A46 Coventry Junctions (Walsgrave) Scheme number: TR010066

5.2 Consultation Report Annexes **Annex O: Tables evidencing regard had to section 51 advice**

CONSULTATION REPORT ANNEXES
Annex O: Tables evidencing regard had to section 51 advice

Section 51 advice regarding draft application documents submitted by National Highways

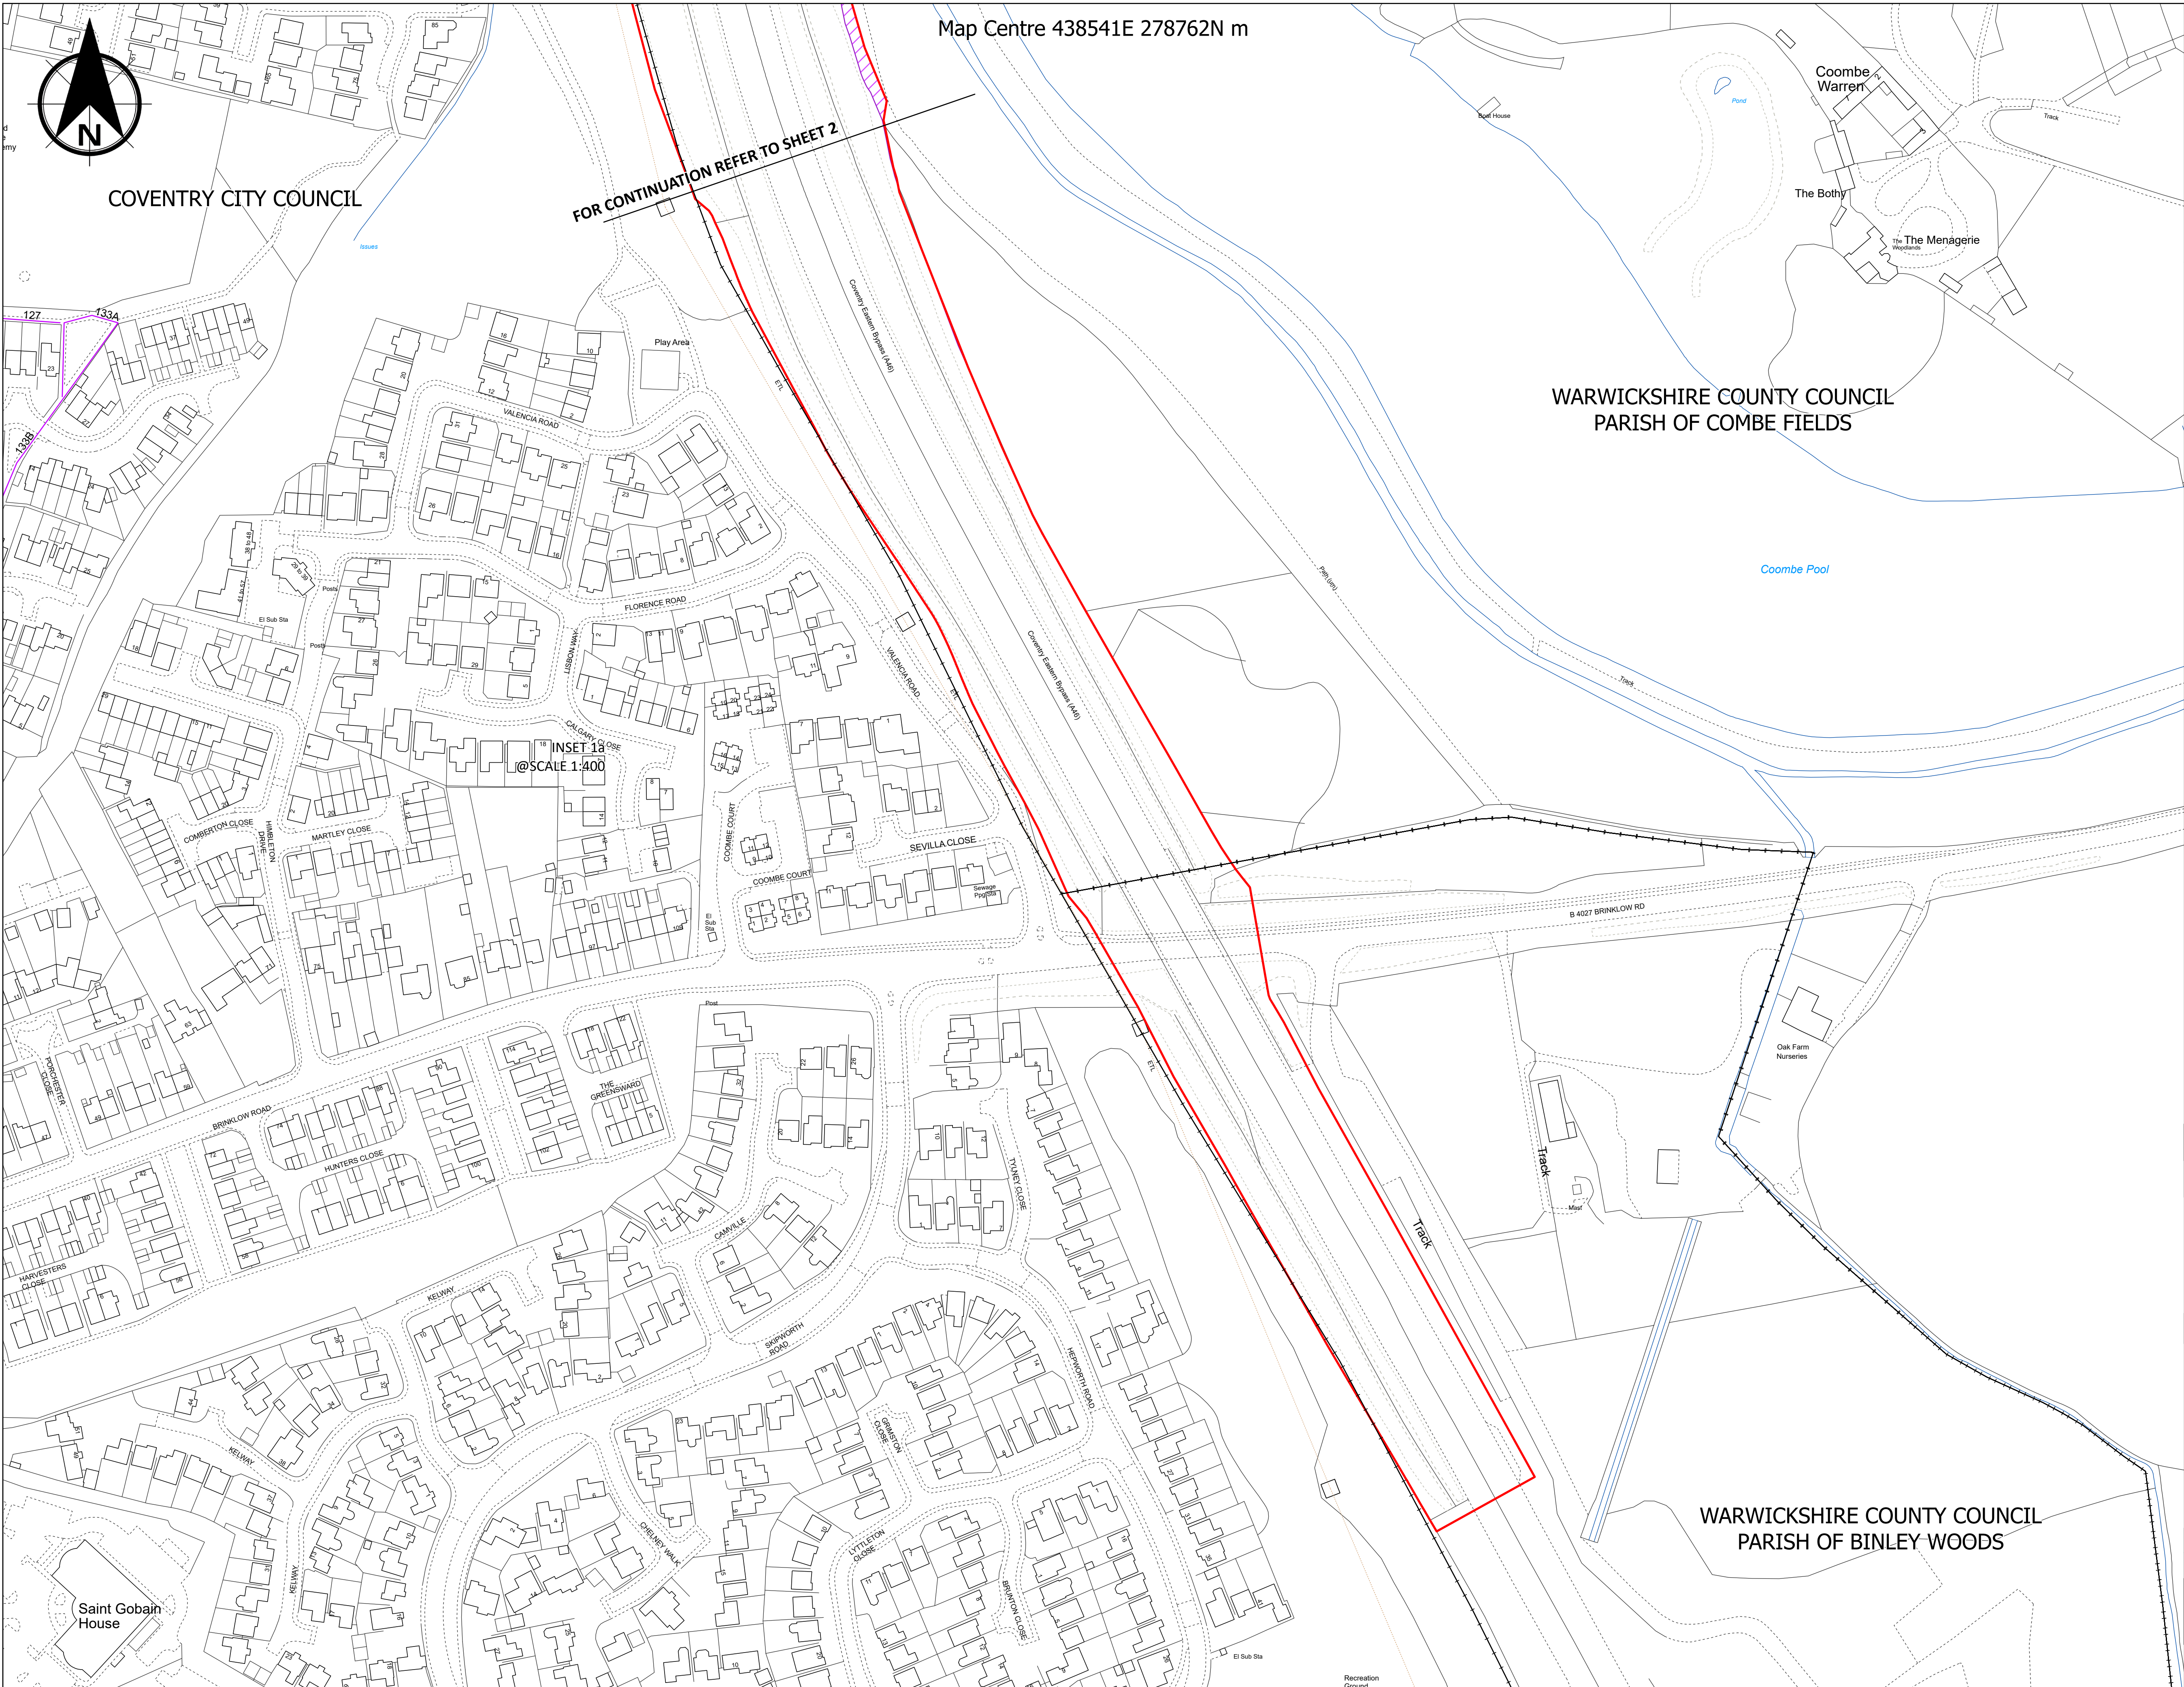
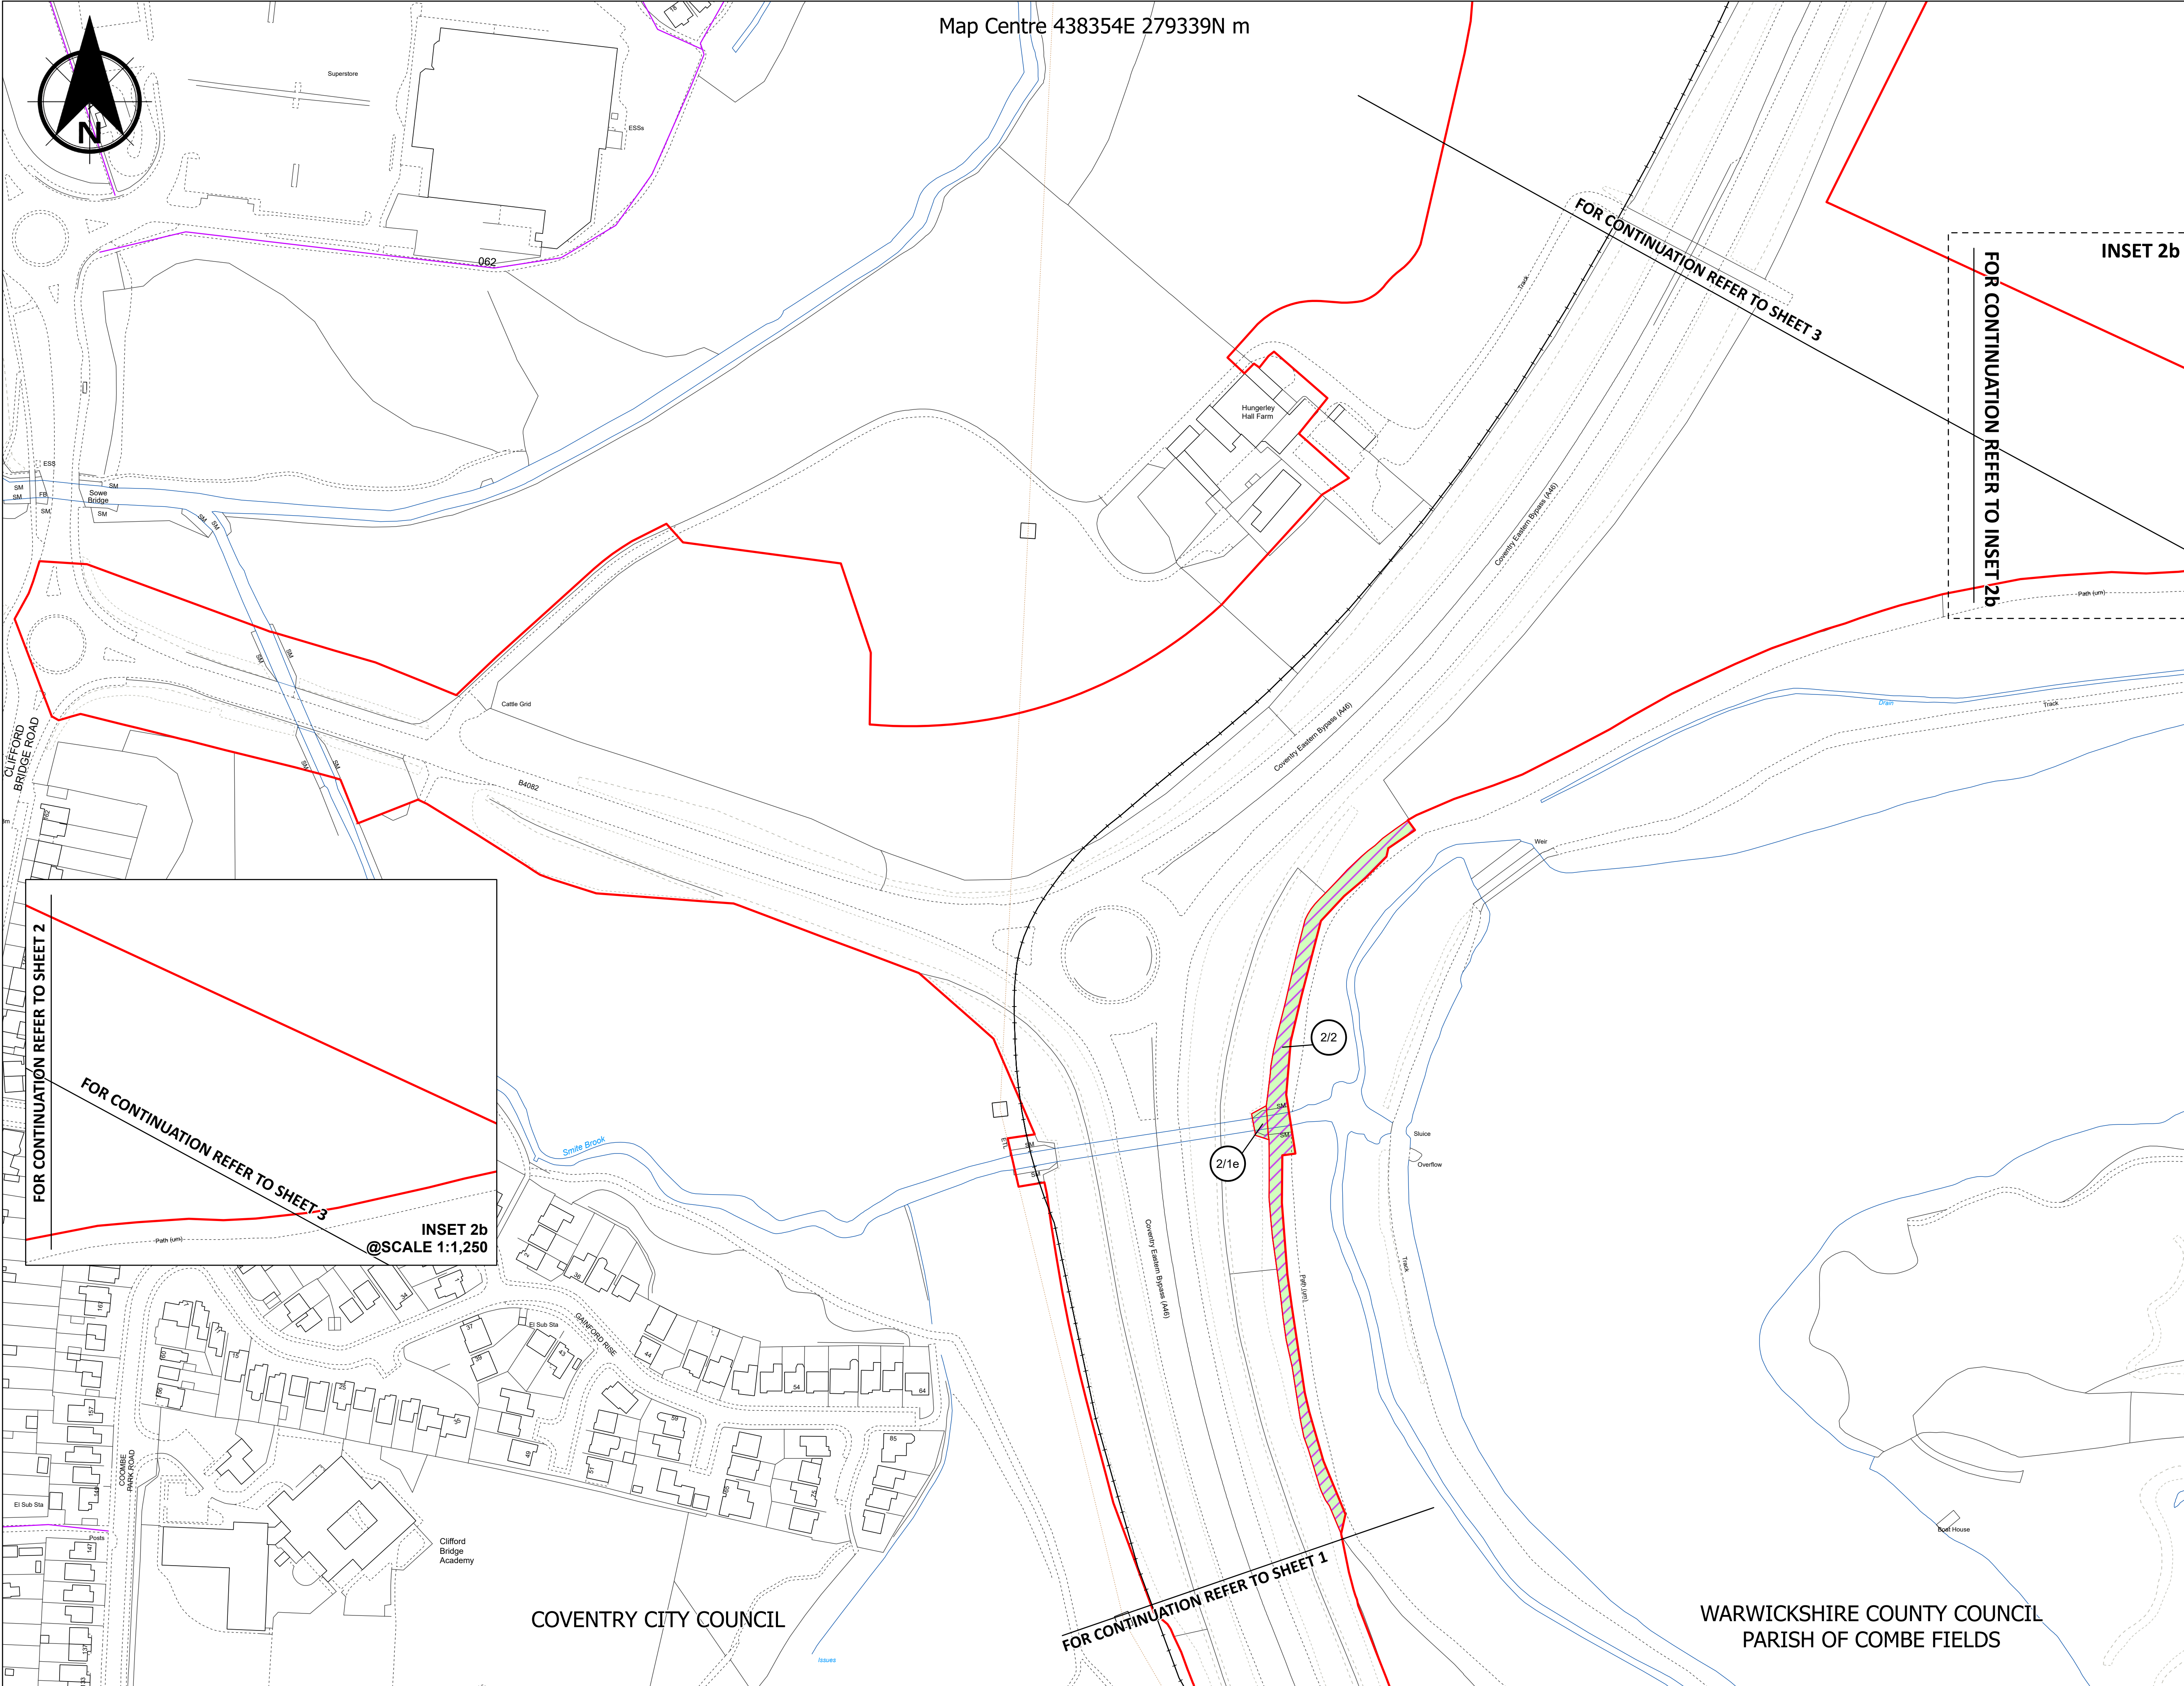
Sheet 3 of 5	<i>As above – ensure there are clear cut lines across all plan sheets as per APFP Reg 5(2)(i).</i>	The Applicant has reviewed and updated the Land Plans (TR010066/APP/2.2) as required to ensure there are clear cut lines across all plan sheets as per APFP Reg 5(2)(i).
		<i>The Applicant should consider having lines between the cut lines for the insets and the zoomed in scale boxes to show easily where they are.</i>	The Applicant has amended the Land Plans (TR010066/APP/2.2) so that the lines between the cut lines for the insets and the zoomed in scale boxes show easily where they are.
		<i>Sheets 2a and 3a are just titled 'Sheet 2, Inset 2D' and 'Sheet 2, Inset 3C' and should be titled 'Sheet 2A....' and 'Sheet 3A...'</i>	The Applicant has amended the titles of the sheets on the Land Plans (TR010066/APP/2.2) as suggested.

Ref No.	Paragraph/ Section	Comment or question (The Planning Inspectorate)	Applicant's regard to section 51 advice
	Sheet 1 of 5	<i>Please identify in the key the small triangle to the right of Plot 1/4 which is edged red but not coloured or numbered.</i>	This is an error and should not have been included, the Land Plans (TR010066/APP/2.2) Sheet 1 has been amended to remove this.

Sheet 3 of 5	<i>Ensure in '3A' all plots are labelled.</i>	This has been reviewed and all the plots are now labelled in the Land Plans (TR010066/APP/2.2).

Sheet 2 of 5	<i>Ensure all plot numbers are in the cut lines as well as the zoomed in scale box.</i>	All plots are clearly labelled on the Land Plans (TR010066/APP/2.2).
